RWE Generation UK plc

TILBURY 2 Examination – TR030003

Submission of Comments on behalf of Interested Party RWE Generation UK plc

**Submitted at Deadline 4
22 May 2018**

LONG SECTION - FORT ROAD WORK NO. 10

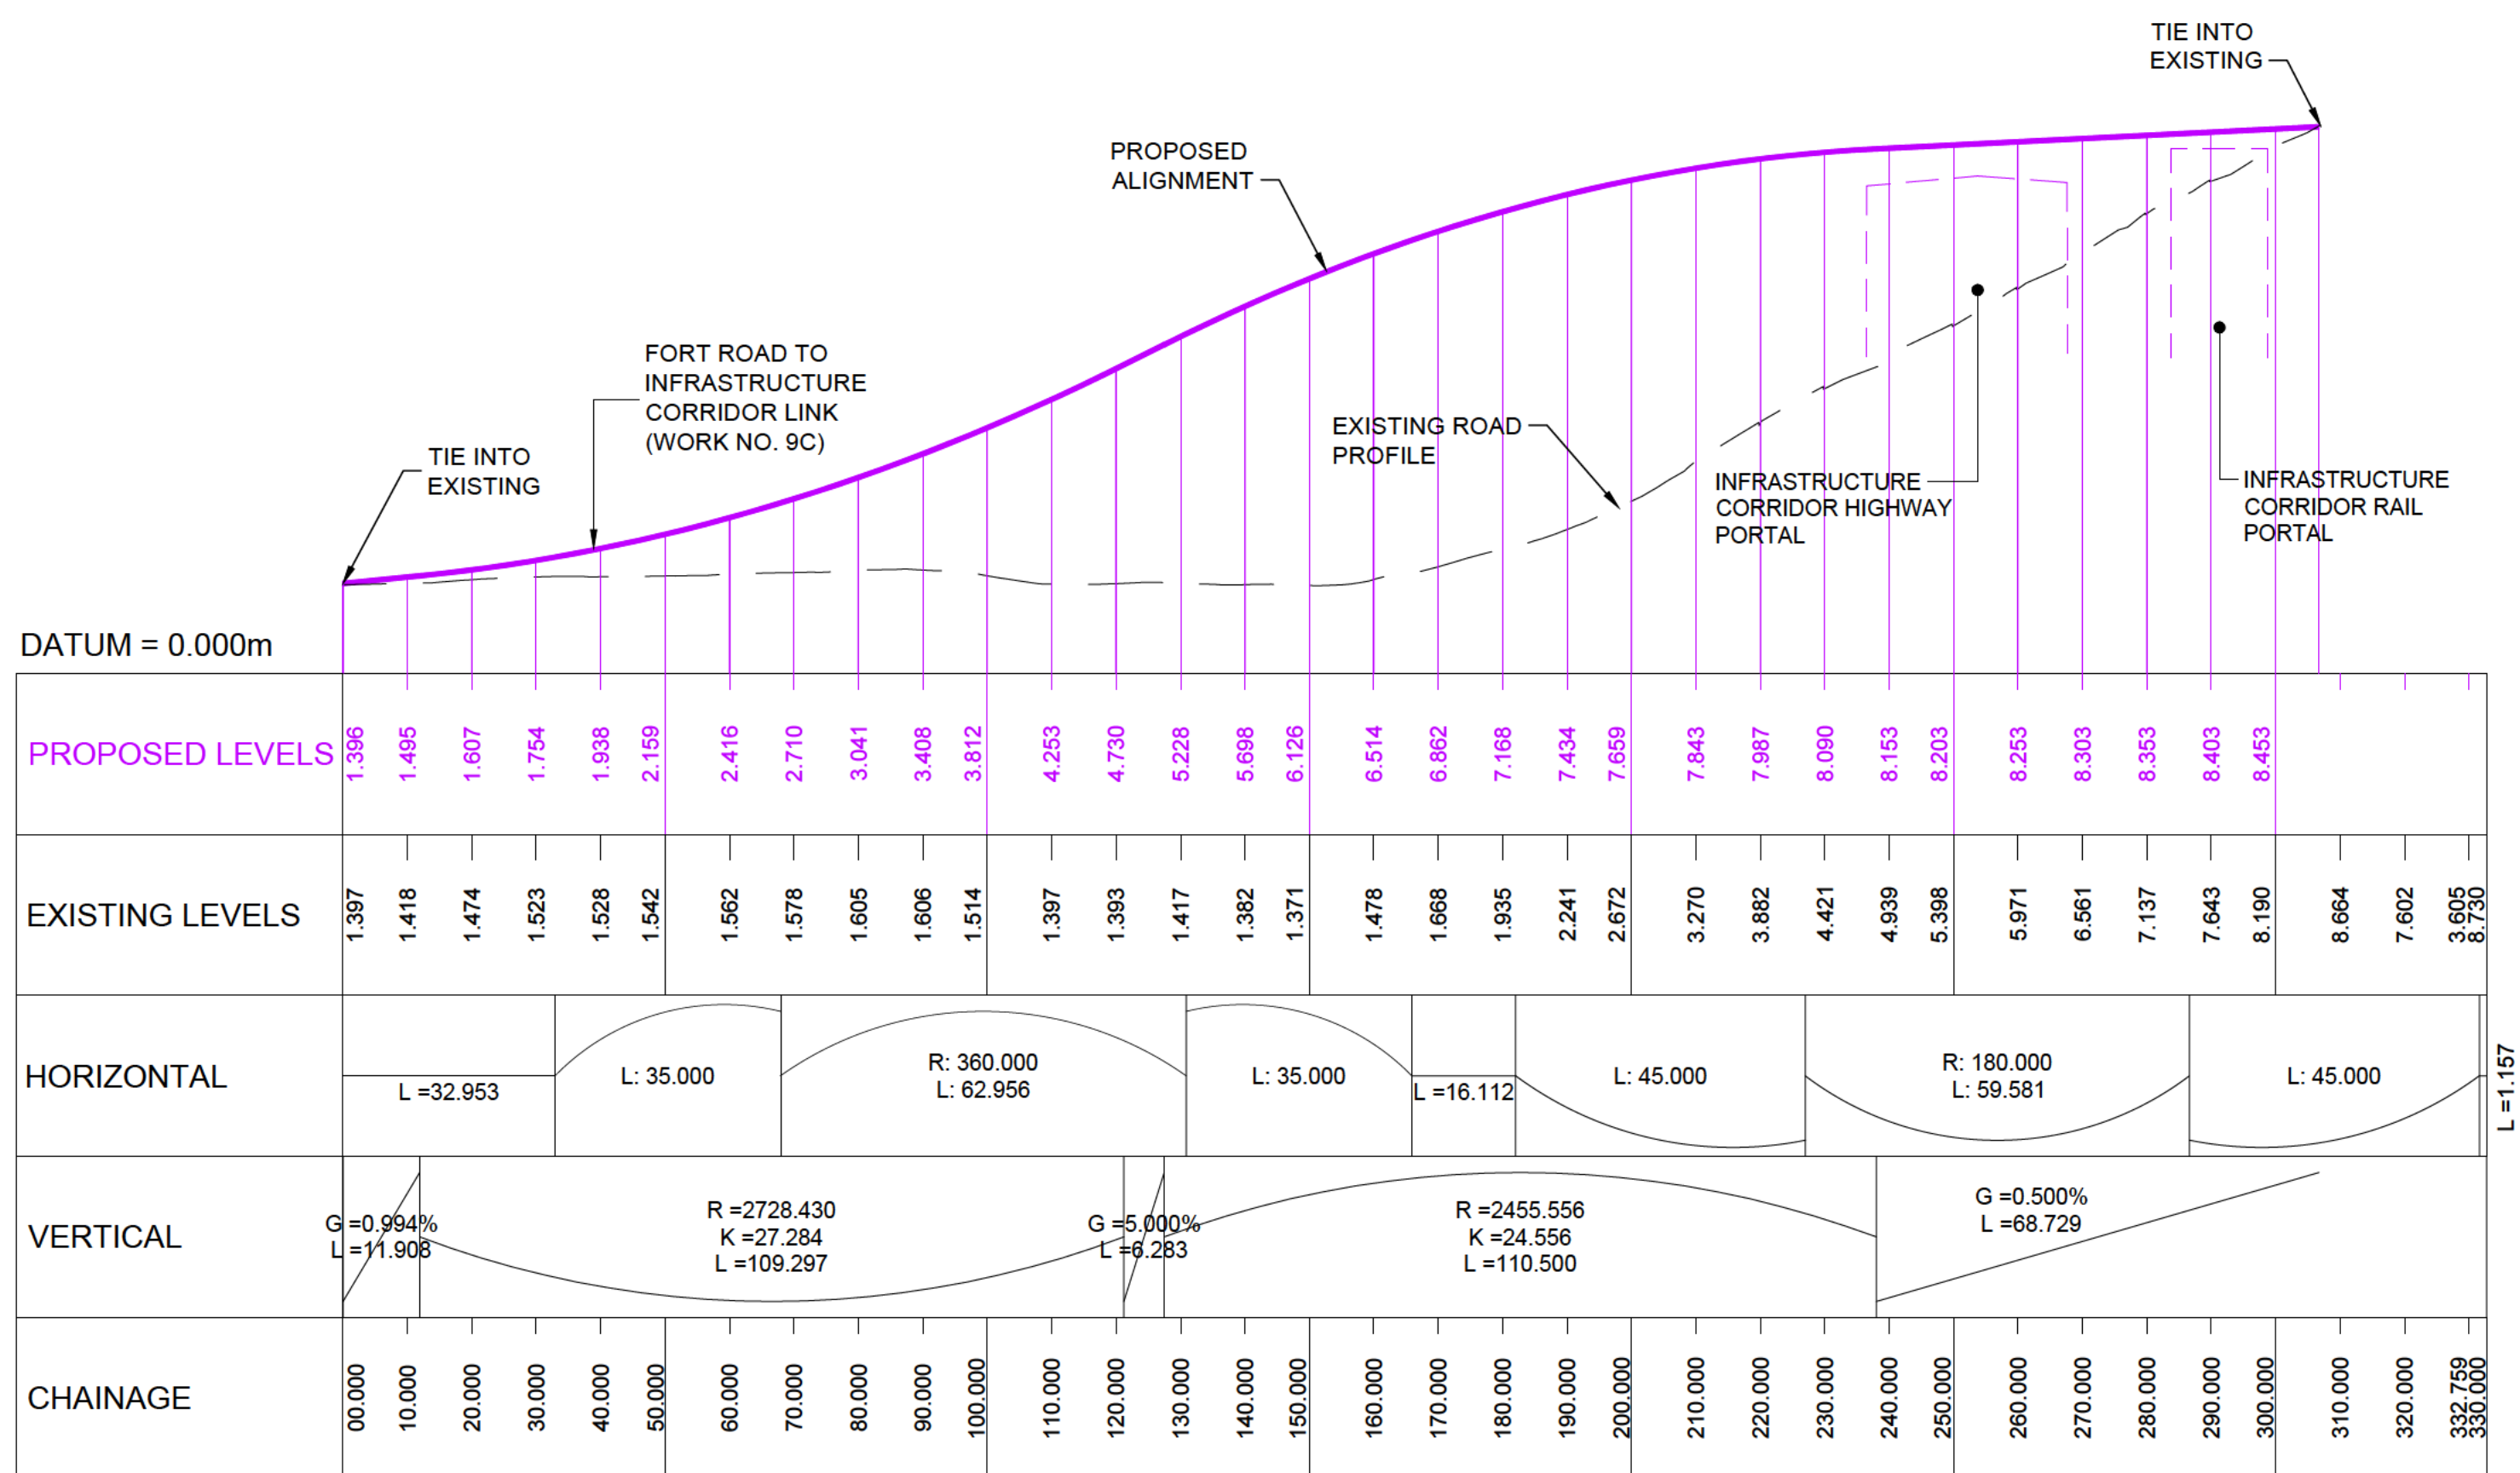
2.2 The Applicant's proposed overbridge at Ford Road (Work No. 10) causes RWE concerns in terms of the resulting height restriction of 5.3m, which would hinder delivery of power station construction loads to the TEC site. RWE acknowledges that the Tilbury 2 dDCO provides the ability for the Applicant to lower the road under the overbridge at Fort Road (Work No. 10). This would potentially address RWE's concerns providing the resulting height restriction is a minimum of 6.3m and providing the Applicant is able to identify an alternative suitable unrestricted access to the TEC site through the Port capable of accommodating abnormal loads.

LONGSECTION-WORK NOS. 6 & 8C

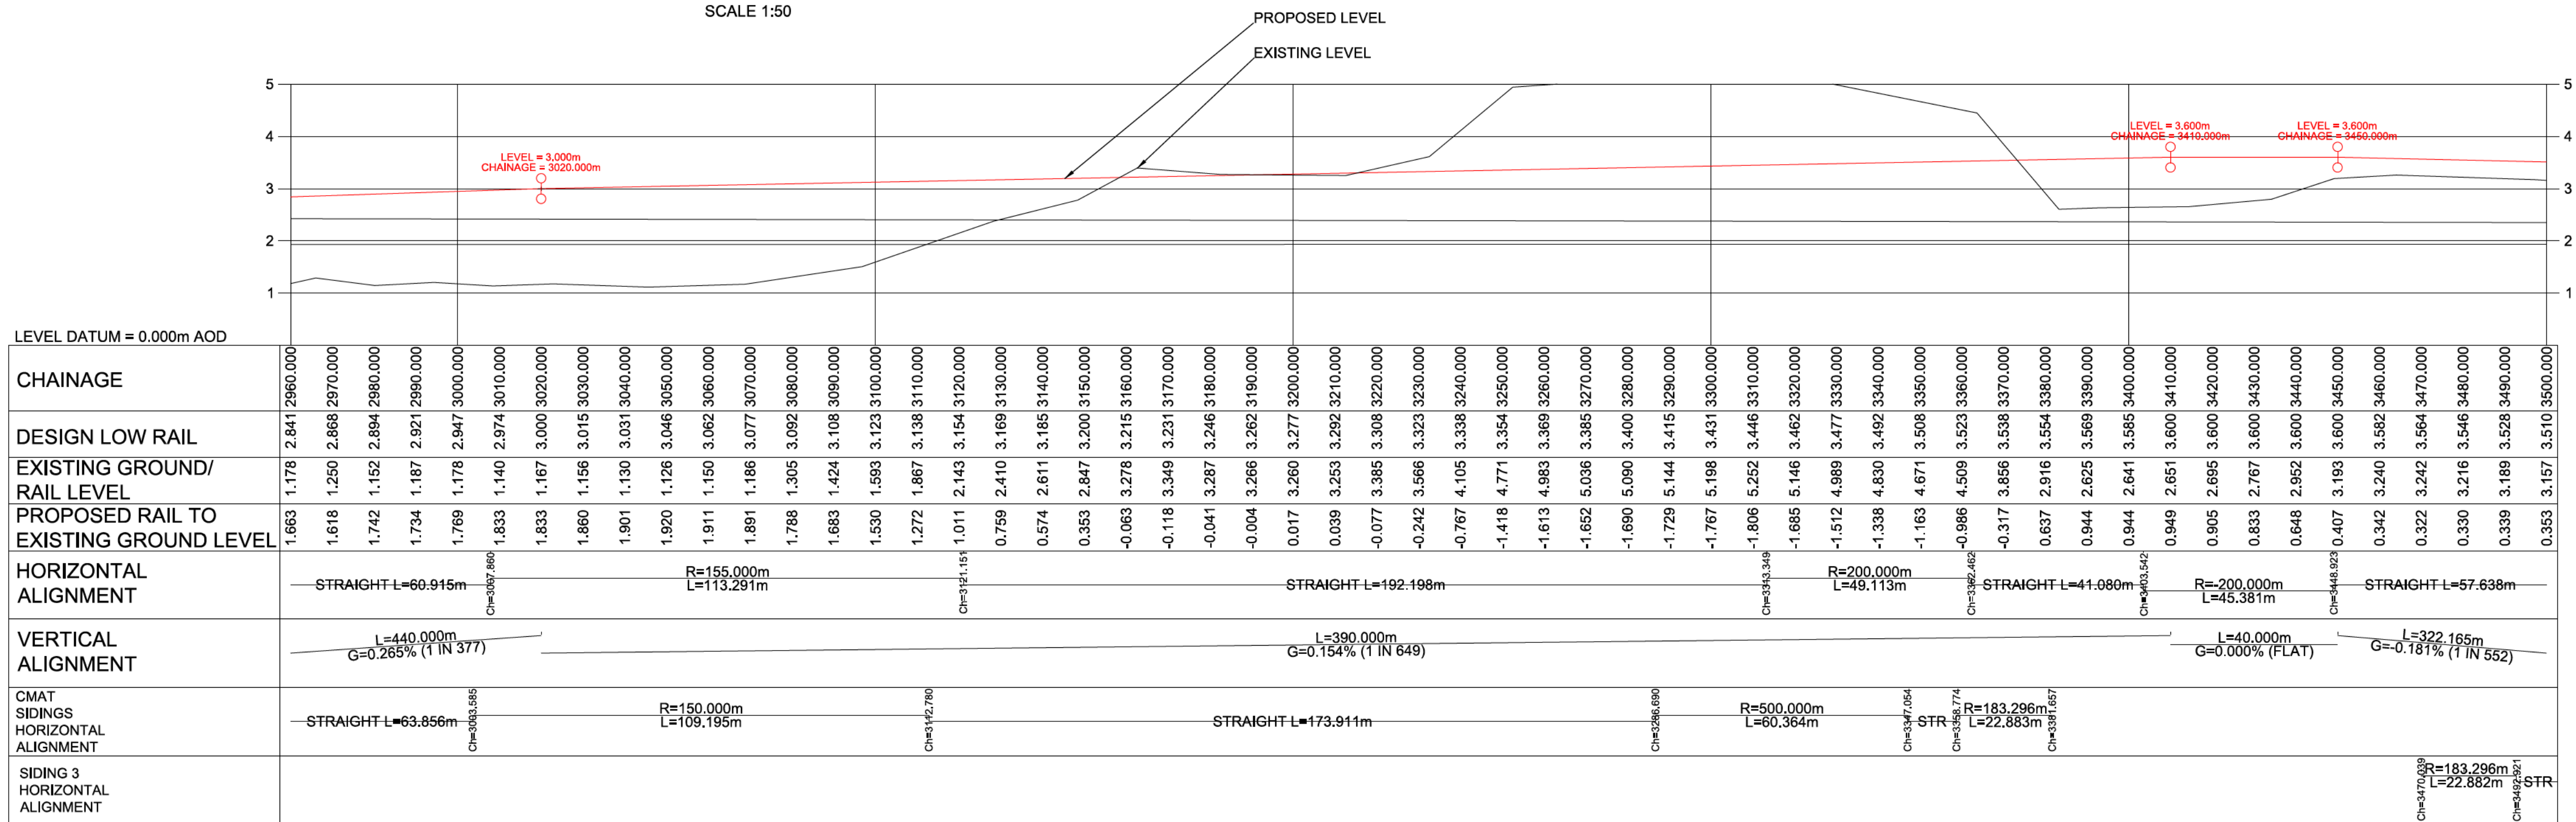
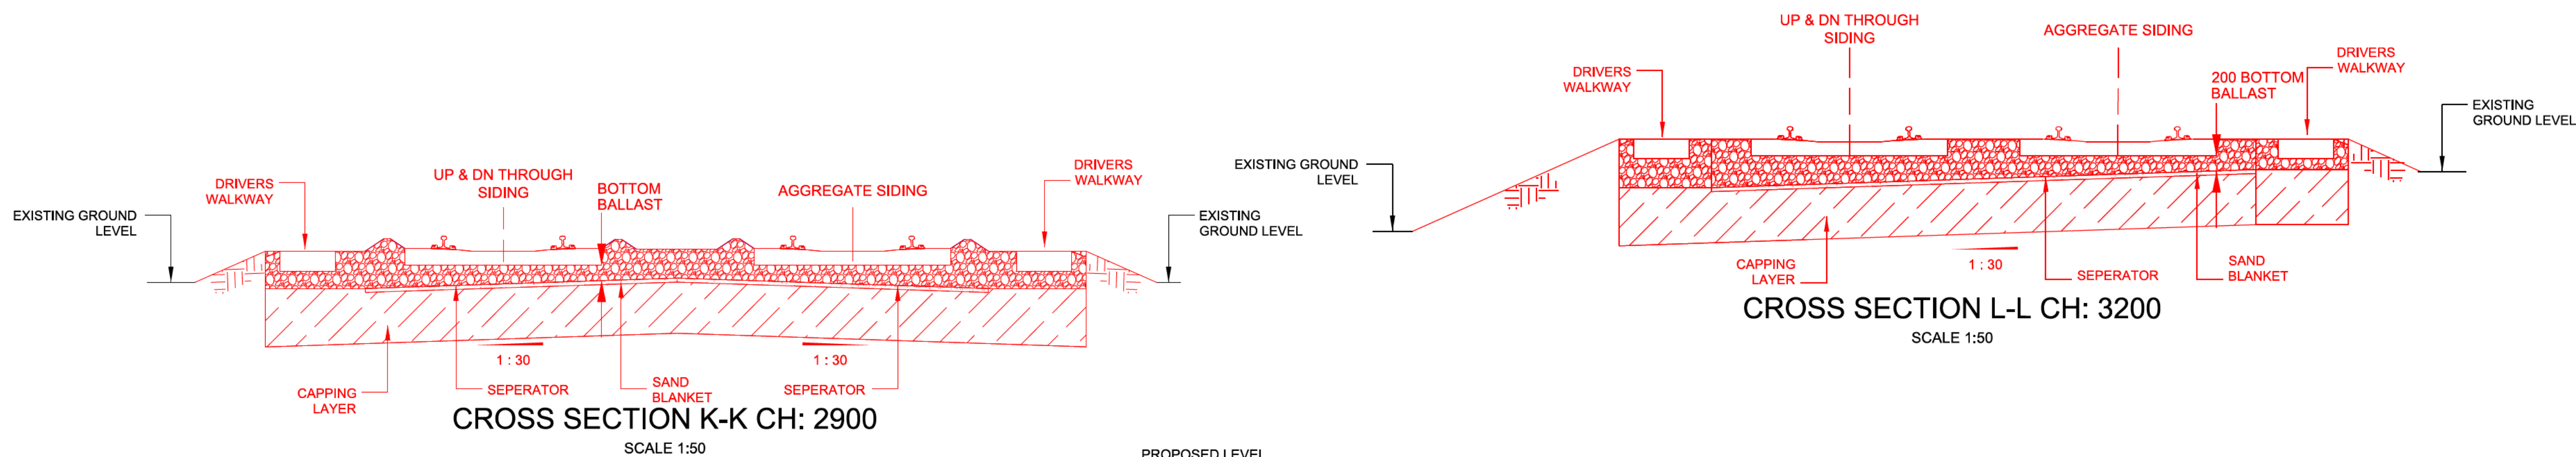
2.3 RWE remains concerned with the implications of the Applicant's proposed Rail Spur (Work No. 8 C), which will cross the access to the TEC site, and in particular how the Applicant will ensure, in the context of the Rail Spur, that RWE's right of access at all times and for all purposes will be upheld.
